MITIGATED DETERMINATION OF NONSIGNIFICANCE

- Project:** Firkins Rezone (Z-08-01) and Preliminary Plat (P-08-02)
- Description:** A rezone from Ag-20 to Ag-3 together with a Preliminary Plat to subdivide approximately 15.03 acres of land into five (5) lots.
- Proponent:** Cam Sherwood
3323 Brickmill Road
Ellensburg, WA 98926
Representing Charles Firkins, landowner
- Location:** The project is located east of the City of Ellensburg, north of Vantage Highway, east of Wilson Creek Road on Game Farm Road, Ellensburg, WA 98926, and is located in a portion of Section 29, T18N, R19E, WM, in Kittitas County. Specific map numbers 18-19-29040-0008 and 18-19-29040-0009.
- Lead Agency:** Kittitas County Community Development Services

FIRKINS PLAT
A PORTION OF SEC. 29, T. 18N, R. 19E, W.M.
KITITITAS COUNTY, WASHINGTON

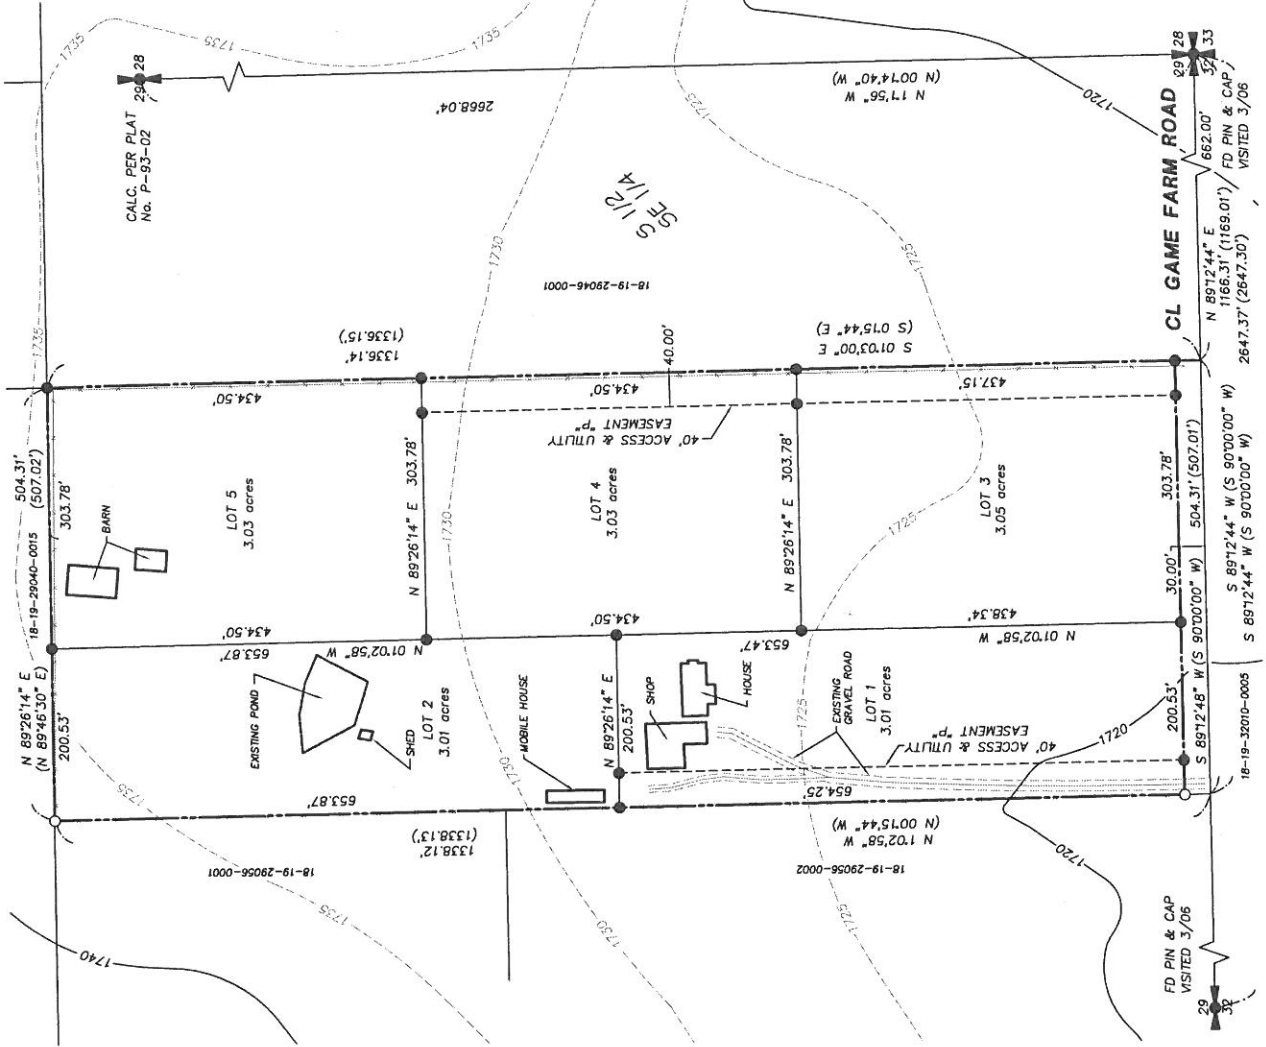
- A. The applicant shall be responsible for meeting or exceeding all conditions and requirements set forth by the Department of Public Works, as listed in the attached memorandum.
- B. There shall be only two access points off of Game Farm Road to serve the proposed subdivision. The two allowed accesses are those shown on the preliminary drawings. One access easement shall serve lots 3, 4 and 5 and end in a cul-de-sac. Lots 4 and 5 shall be accessed from a joint-use driveway beginning at said cul-de-sac.
- C. Lot 3 shall not be allowed direct access solely to and from Game Farm Road, but rather shall use the proposed easement as shown on the preliminary drawings.

- C. The existing well located on lot one (1) of the Firkins Plat (P-08-02) shall be used as a shared well between lot one (1) and lot two (2) of the plat.

- F. The applicant shall develop a "Group B" water system to serve lots three (3), four (4), and five (5) of the Firkins Plat (P-08-02). The "Group B" water system will be designed by a licensed engineer and approved by Kittitas County Environmental Health.
